DECISION DELEGATED TO HEAD OF PLANNING

Application No: H16-0218-25 **Applicant:** Mr A & Mr A Laxmidhar
Proposal: Conversion of first, second and third floors to residential flats together with alterations to shopfront and rear of building
Location: Spalding News 24 Market Place Spalding
Terminal Date: 25th July 2025

**REAR ELEVATION
STAIR OMITTED**

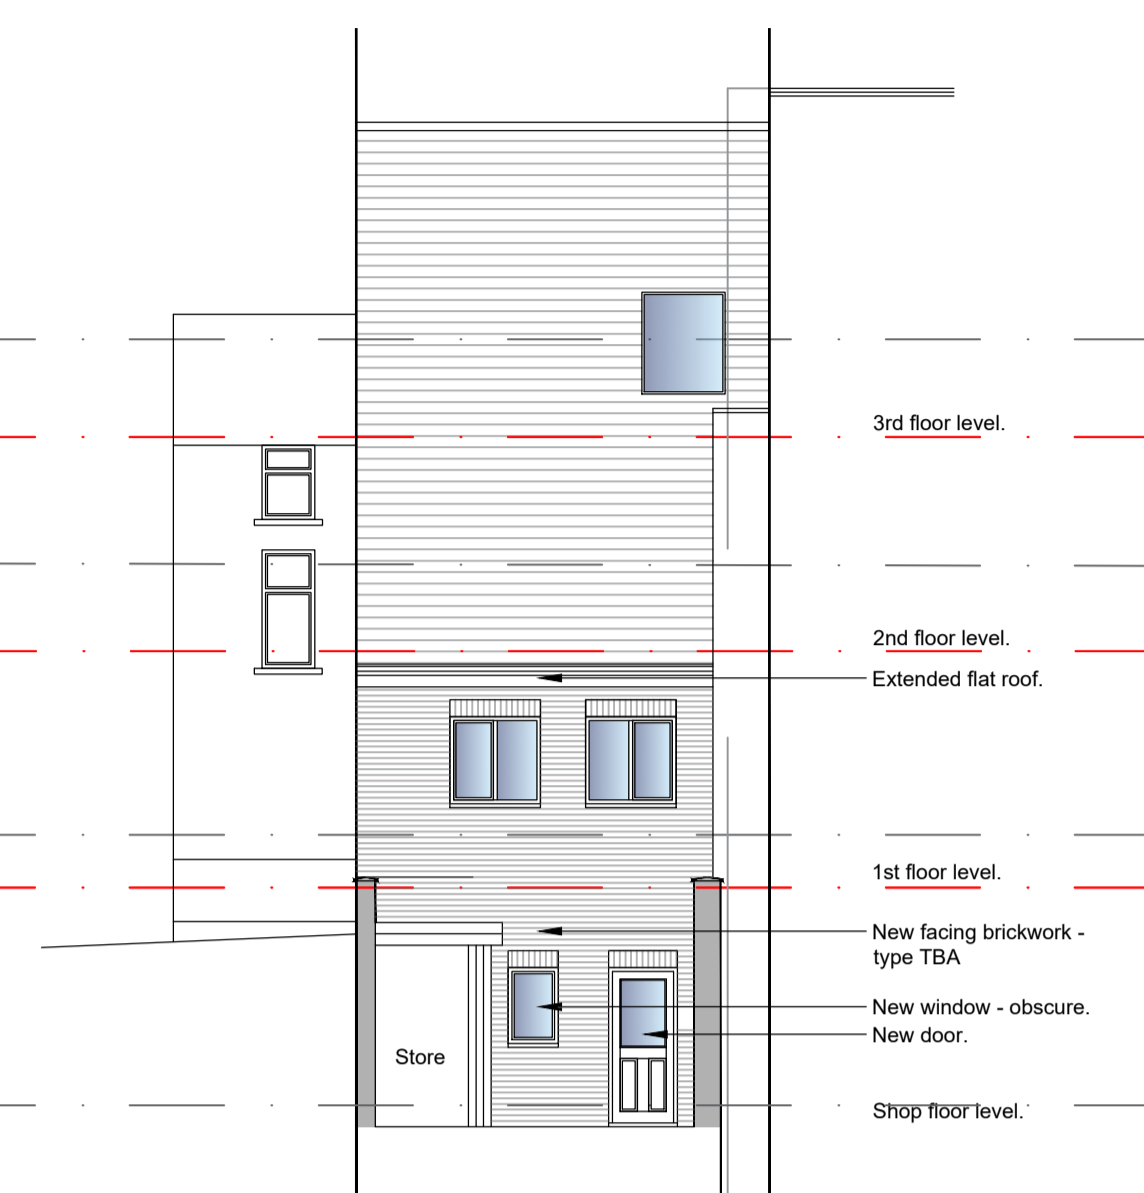
To the rear it is intended to partially demolish an existing flat roof structure, remove an external staircase and construct a larger flat roof addition. With reference to the rear elevation, the Heritage Impact Assessment states: "*The 1887 map clearly indicates that the rear of the site comprised a cluster of blocks around two enclosed yards. Full development of the space was clearly not extant at the time. It can therefore reasonably be concluded that the rear of the site was infilled, likely during the 20th Century...The mineral felt roof covering would suggest that building work also took place possibly in the 1970s or later*". The rear elevation of the building has been significantly altered with little historic value remaining, whilst flat roofs are not encouraged on listed buildings, given the presence of the existing flat roof it is not considered that the proposal would cause further detriment to the appearance of the building, moreover, the removal of the external staircase will result in a degree of visual enhancement.

**Entrance - Elevation
As Proposed**

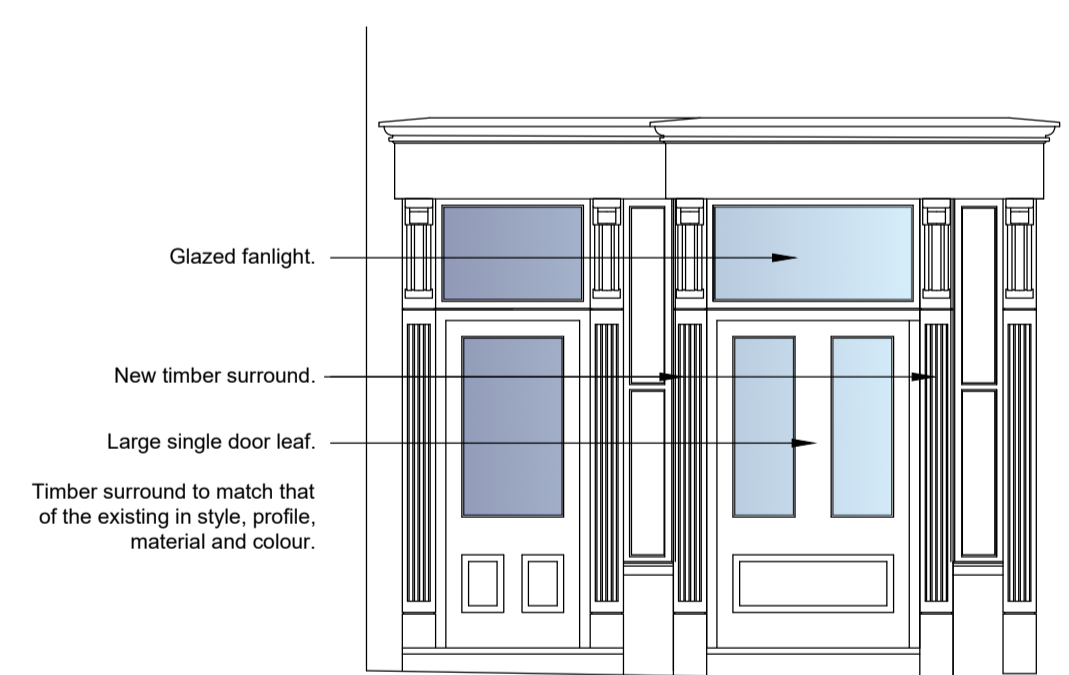
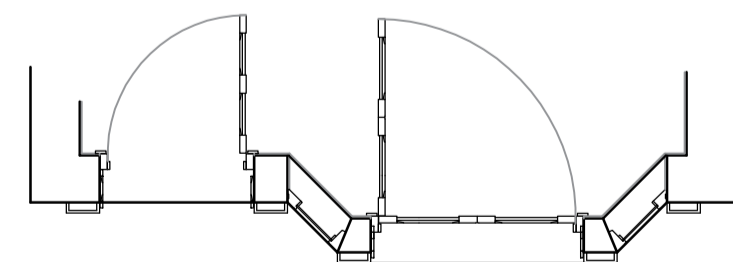
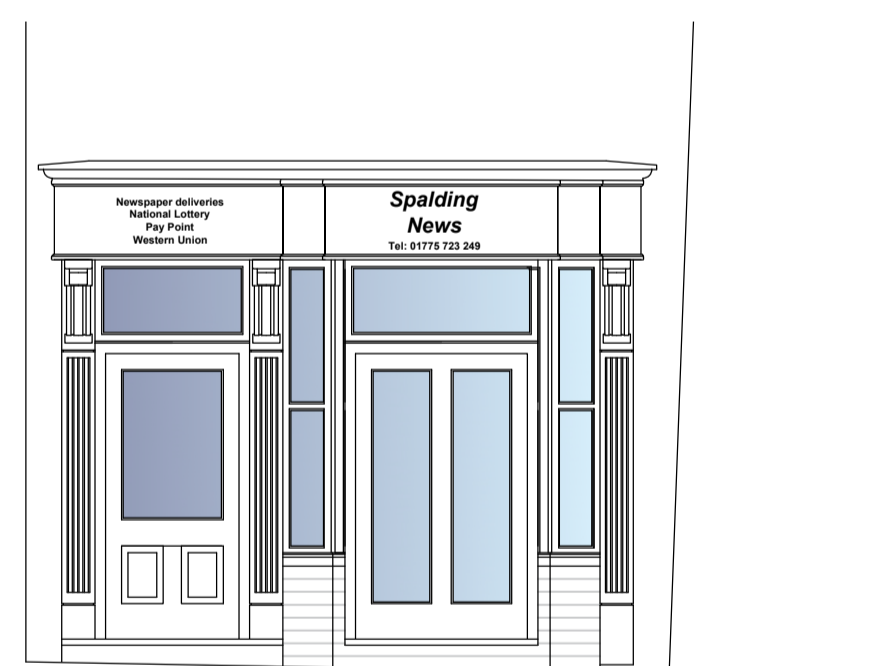
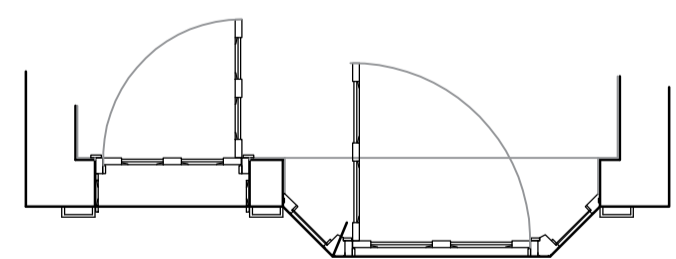
No objection in principle to the proposal, but concern that the proposed shop front alterations do drastically reduce the visible shop front character of the site.

As submitted, concern was raised at the design of the resulting shop front. The central panel to the bay window was to be replaced with a single door, of solid construction other than two glazed side panels, significantly reducing the visible shop front character of the site. Whilst it is acknowledged that the shop front as exists is not original and dates from 2010, it nonetheless reflects the historic character of the original structure and in this respect has a degree of value. Moreover, this in itself is not a reason to replace the shop front with a design that creates visual harm to the listed building.

Discussions subsequently took place with the applicant's agent along with the conservation officer. The agent was requested to consider retaining a single door with an internal porch providing separate access to the retail unit and apartments. However, it was advised that this was not feasible, given the limited floor area of the commercial premises any reduction in this would affect its viability. A revised design was submitted, replacing the central bay panel with a glazed door, central solid panel and increasing the level of glazing to the sides. It is considered that the amended scheme serves to retain the visibility of the shop front bay and the design would preserve the architectural and historic interest of the listed building.
